From: Breezie Allwright <Breezie.Allwright@arun.gov.uk>
Sent: 12 January 2026 08:26
To: Planning.Responses <Planning.Responses@arun.gov.uk>
Subject: Fw: R/215/25/HH

From: [REDACTED]
Sent: 28 December 2025 12:48
To: Breezie Allwright <Breezie.Allwright@arun.gov.uk>
Subject: Re: R/215/25/HH

Drawing:  
**Plans and elevations as proposed**

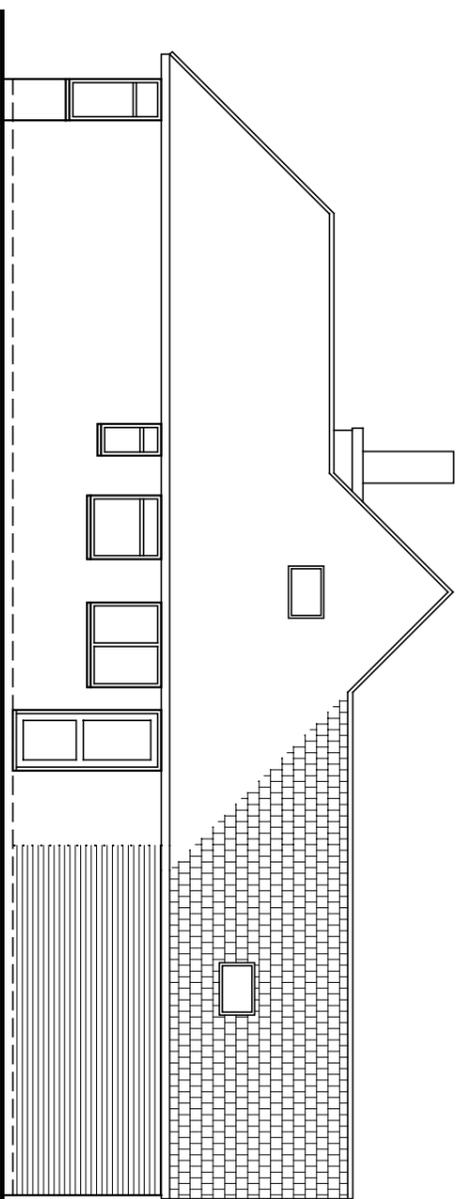
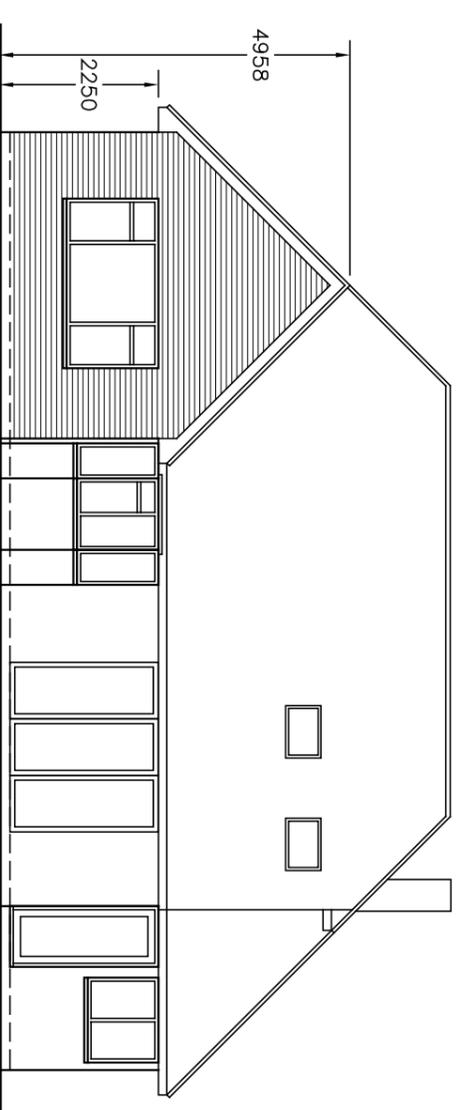
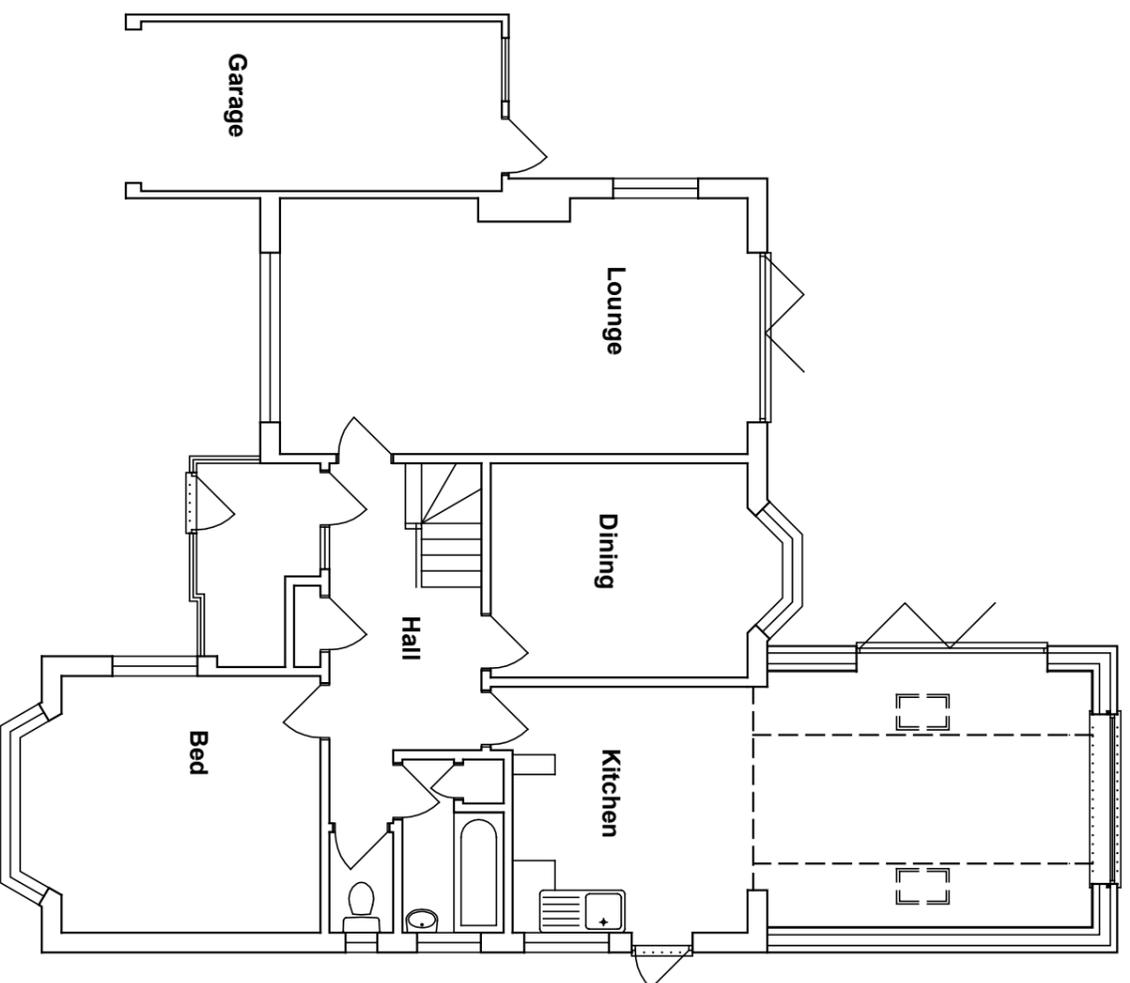
The extension overshadows or overlooks a J WOODS 1 EVELYN AVE ,key windows TO MAIN LIVING AREA AS HEIGHT IS TOO CLOSE

"BLOCK PLANS SHOWS CLEARLY"
EXTENSION , WOULD APPEAR AS" BRICK WALL AND GUTTER" VIEWABLE
INTRUSIVE AND UNSIGHTLY

OVERSHADOWING OVERBEARING,INTRUSIVE UNSIGHTLY, IS SEEN VIA BLOCK PLAN, MAIN LIVING ROOM, AND SUN CONSERVATORY THAT SERVES MAIN LIVING ROOM AND SLEEPING AREA,WHERE WINDOWS THAT RECEIVES HEAT AND LIGHT

Proposed plans will leave "21 ft of brick wall and gutter " , running along my south border view,
in my direct view from my home,
my south border outlook would be unsightly over shadowing overbearing ,intrusive unsightly

my south border where light comes from is where thompsons plan to build ,wall and gutter will be high enough to make this occur
